**Application Reference: 2026/0295**

**Site Address:** 3 Rydal Close, Penistone, Sheffield, S36 8HN single storey front extension, conversion of integral garage to habitable area, 2 storey rear extension, widening of driveway to create extra parking space, removal of rear single detached garage and replace with detached double garage and alterations to fenestration and doors to dwelling.

Drawing Title: Ground & First Floor - PROPOSED

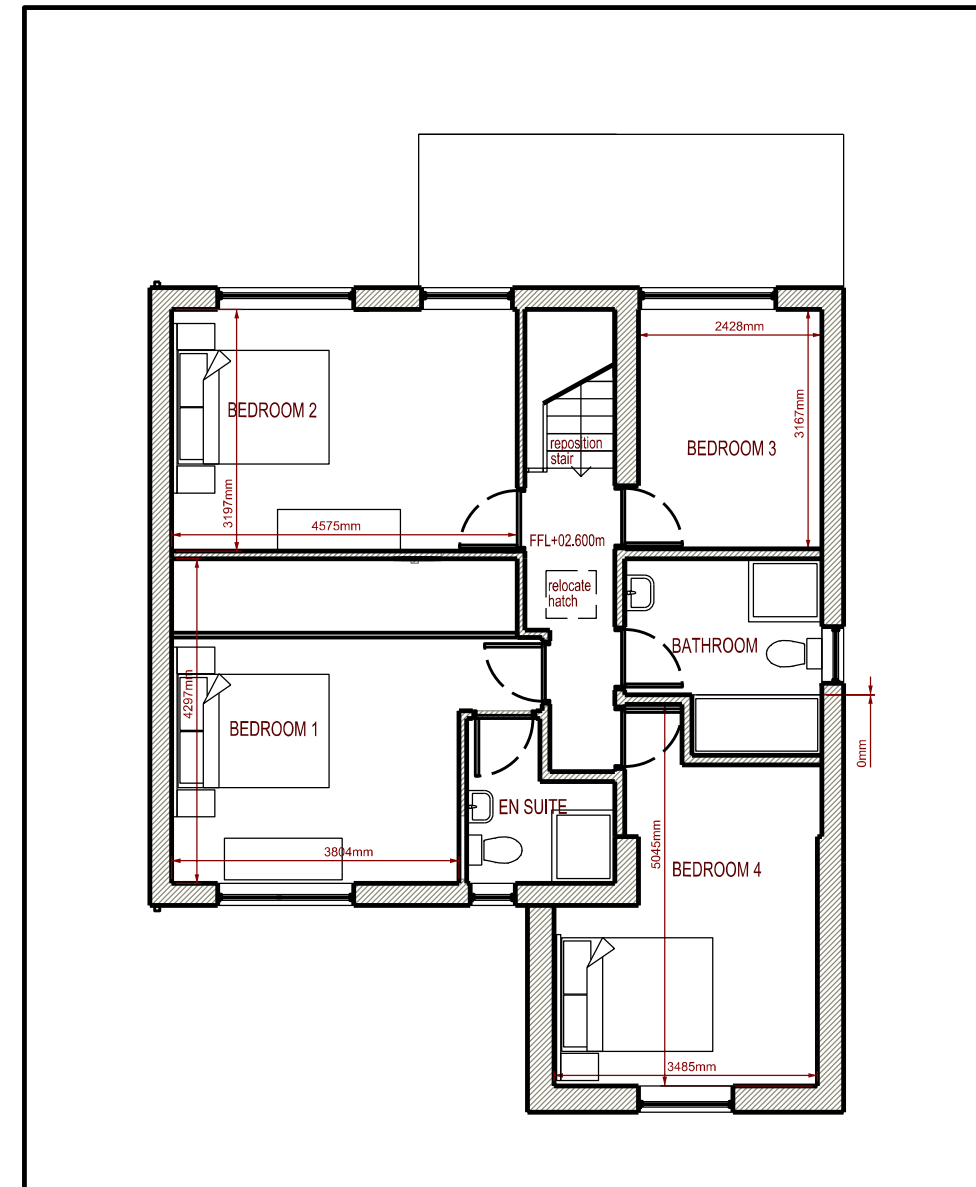
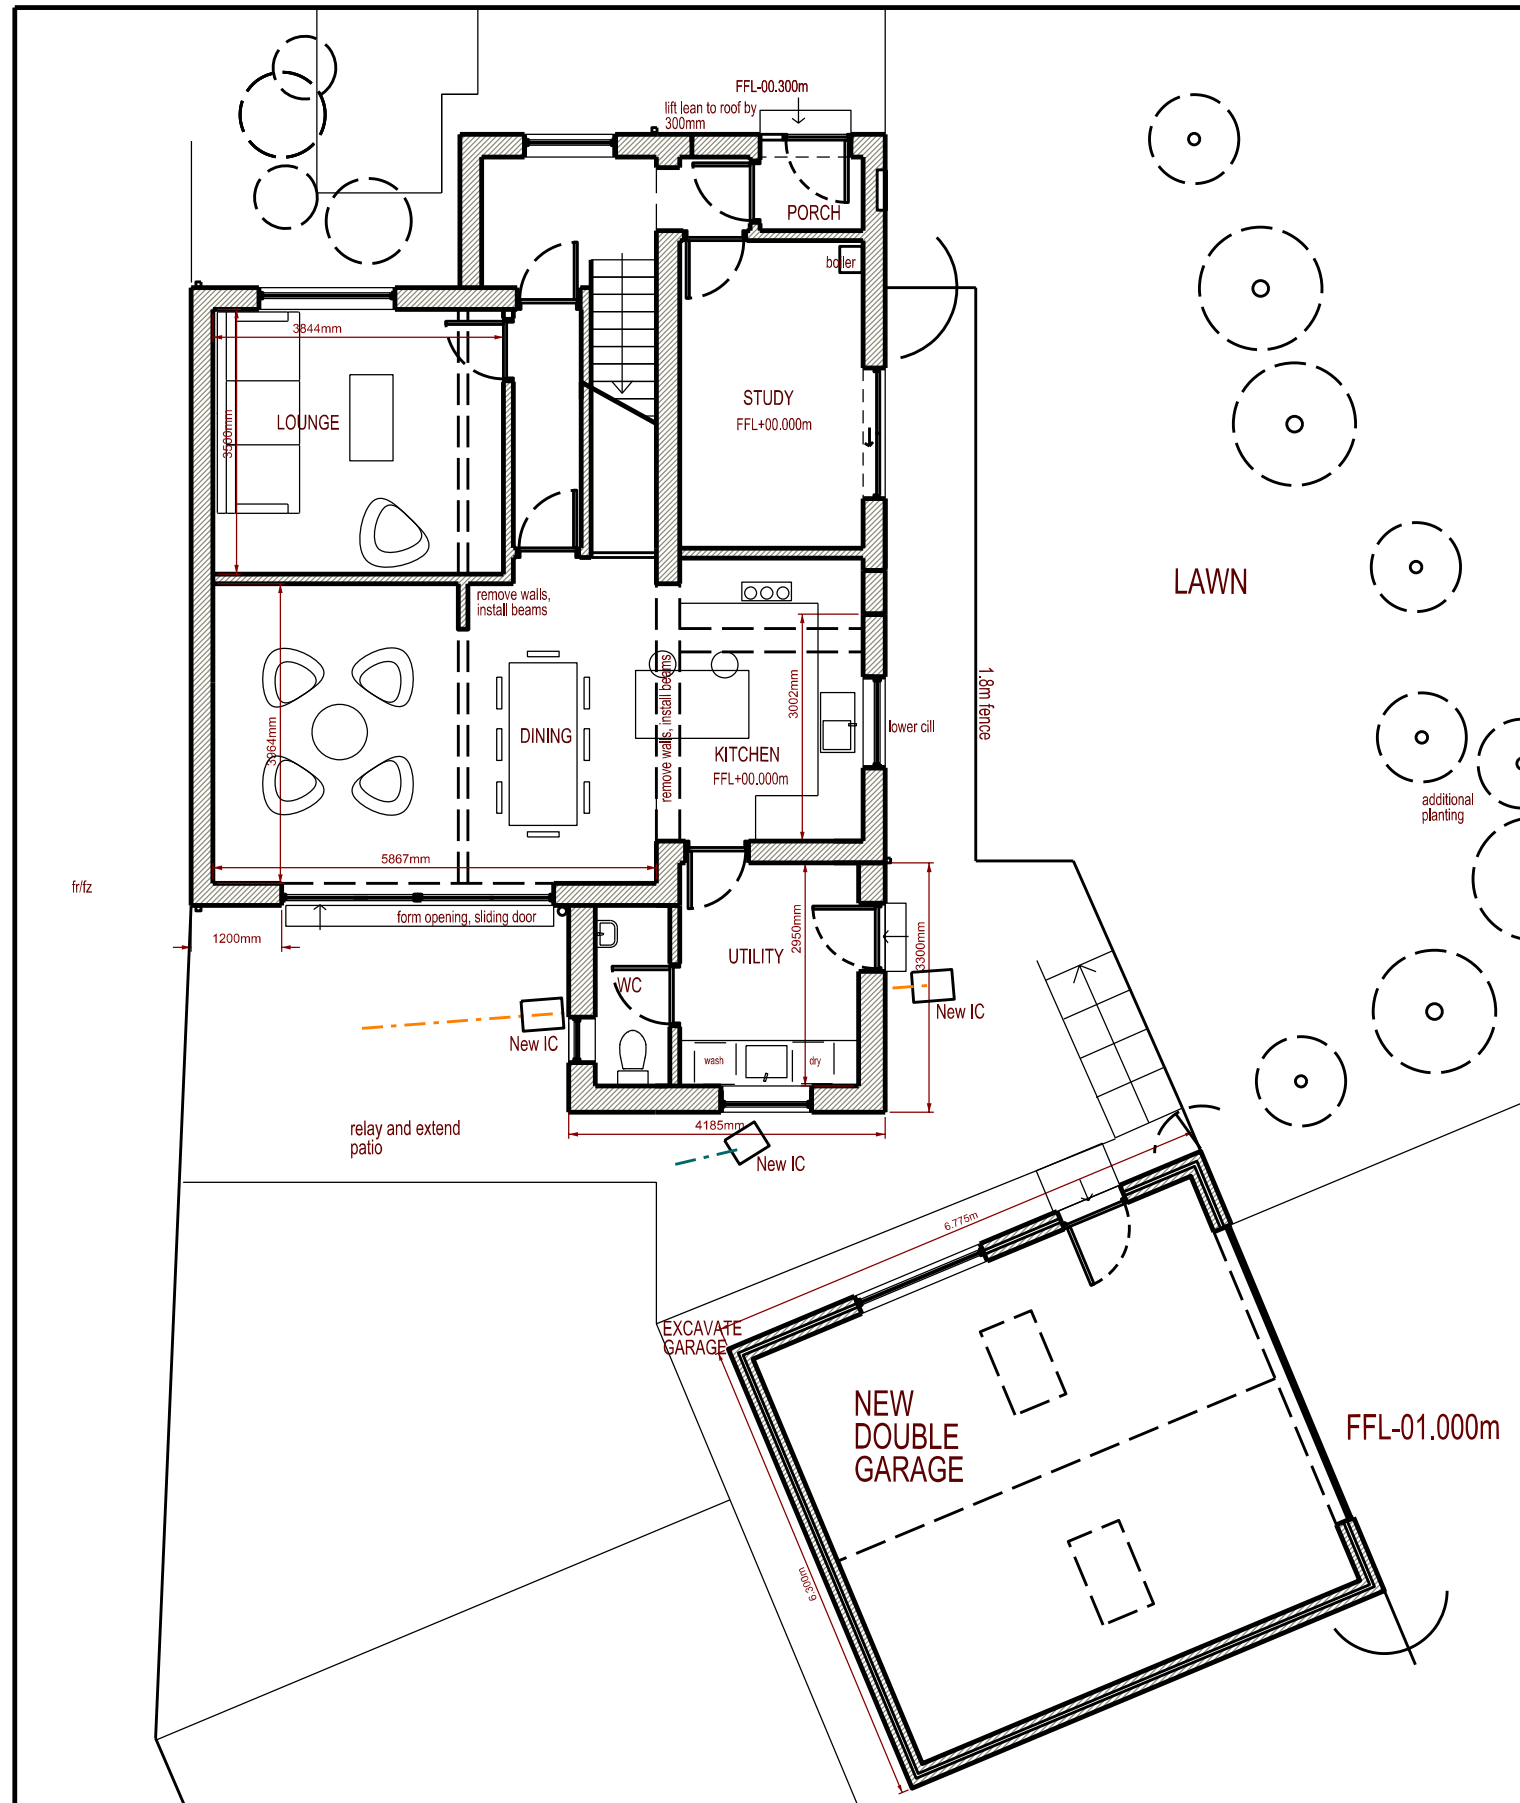
In this latest application, the proposal will finalise those aspects of work already approved and not yet started or completed from the two approved planning applications. The new addition to this proposal, is a request to extend the rear projection of the proposed, and already approved, two-story rear extension. In the last approved planning application of 2026/0033, the rear projection was approved at 3m, in this new application, the proposed rear projection has been increased to 3.3m.

Also indicated on the plans is relocation and replacement of two excising drains, presumably drain manhole covers/inspection chambers. Three new inspection chambers replace the existing two drains. A bi-fold door is also replaced with a sliding door of similar size. There are also some minor internal changes including resizing of the first-floor bathroom.

This application seeks to marginally increase both the ground and first floor rear projection of the proposed two-story extension by 0.3m (30 cm), which would have consequential ground and first floor footprint increases, compared to what has already been approved, of approximately 1.26 sqm each. This would increase the approximate ground floor footprint of the two storey rear extension to 13.76 sqm, and the first floor footprint to 20.76sqm.

With such a modest increase in projection of 0.3m, and a footprint increase of less than 10%, together with no increase in width or roof height, the revised two-story extension would have an insignificant impact in terms of scale and design, when considered in comparison to what has already been approved. The proposal would still remain prominent but remains at a much more acceptable scale than the larger side and rear extension which was refused in application 2025/0270

Drawing Title: Elevations - PROPOSED

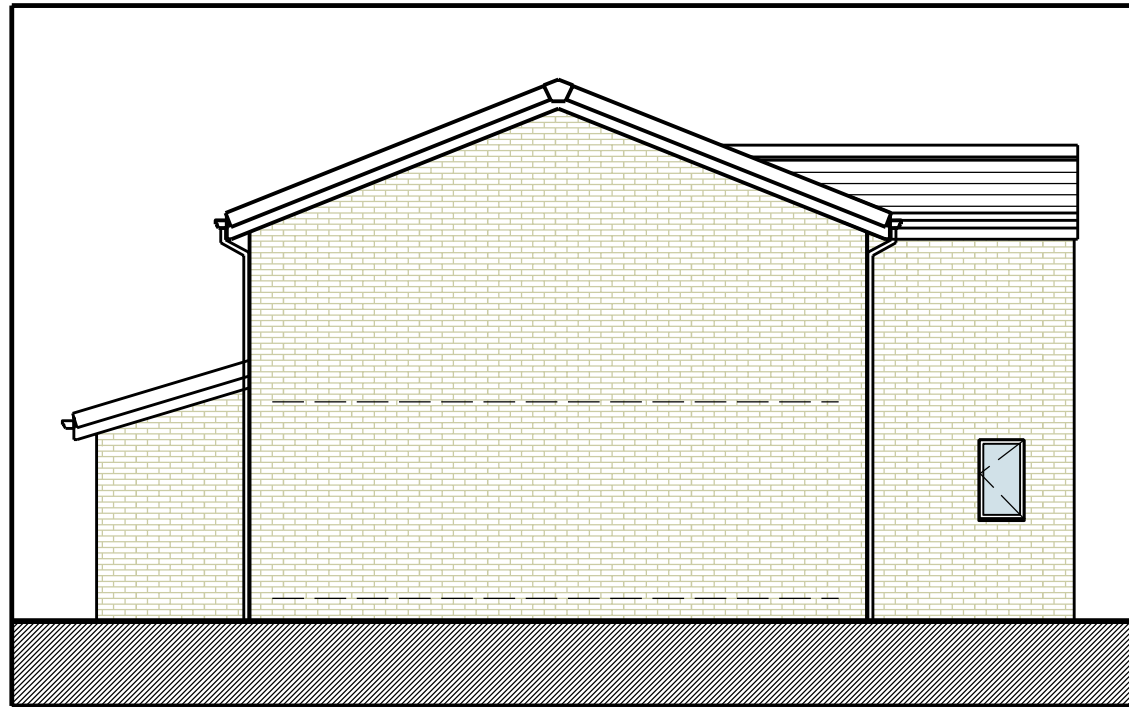
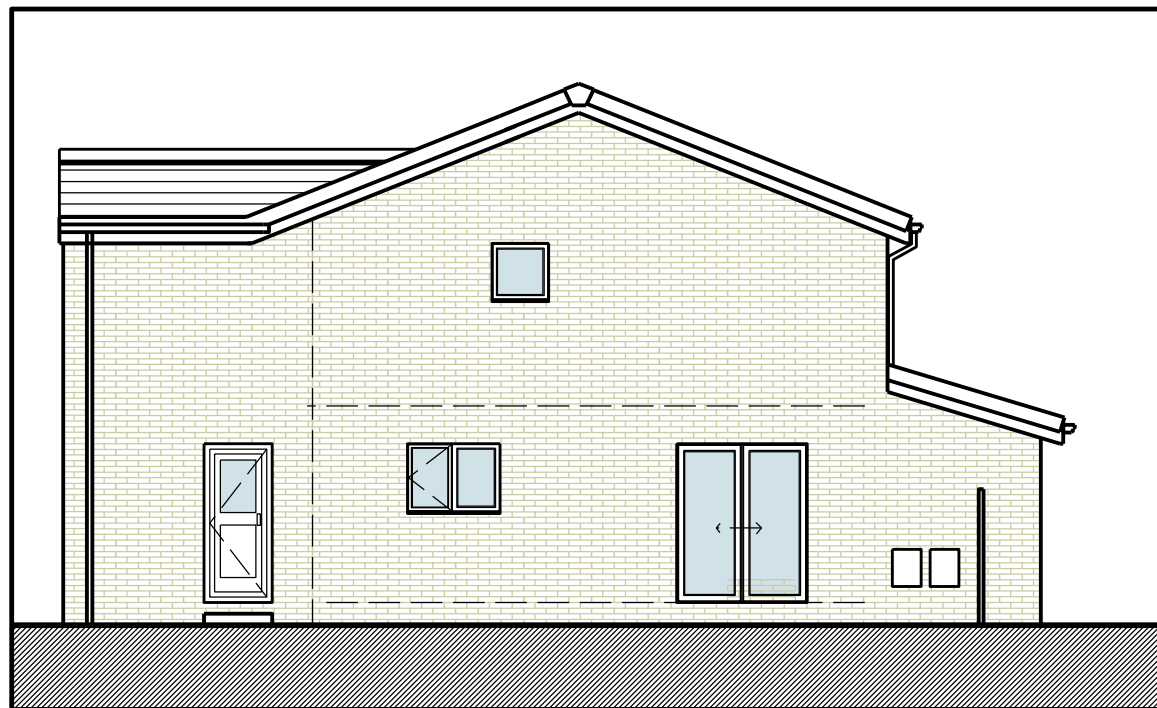
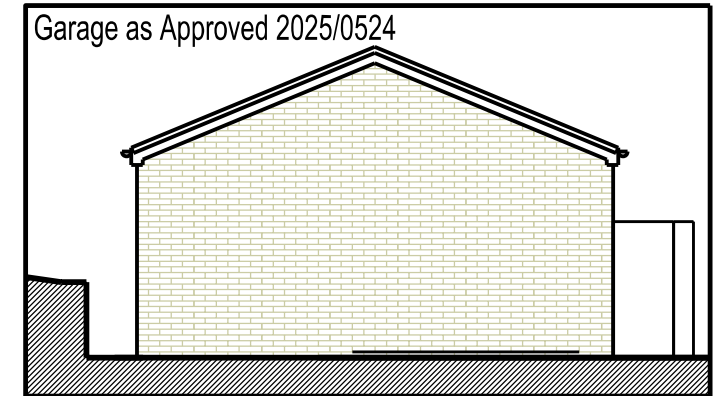
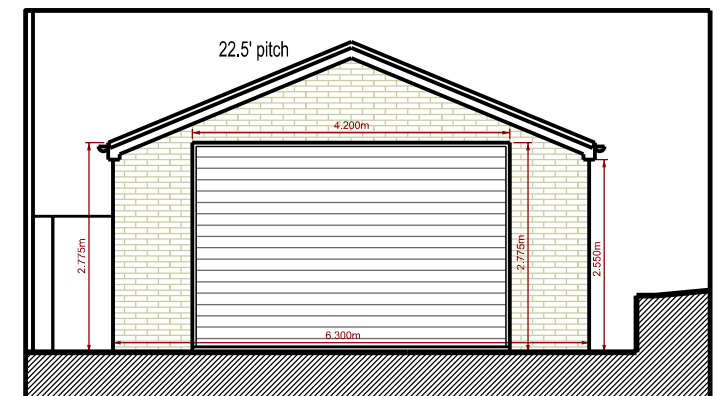
Whilst there would be an undeniable increase in the scale of the proposed rear extension to what was approved previously in application 2026/0333, there is still not expected to be any significant impact on the scale of the house, created by the rear extension, or technically rear and side elevation, even in its proposed larger form. Due to the staggered nature of the rear extension, there would undoubtedly be an impact on the design and consequently the character of the house. However, with the unusual design of the house, it is debatable as whether this impact would be

The proposed windows on the two-storey rear extension remain at an angle to neighbouring properties to the rear, and with sufficient distance from them to avoid any significant overlooking, the impact on neighbouring amenity would again be considered as limited.
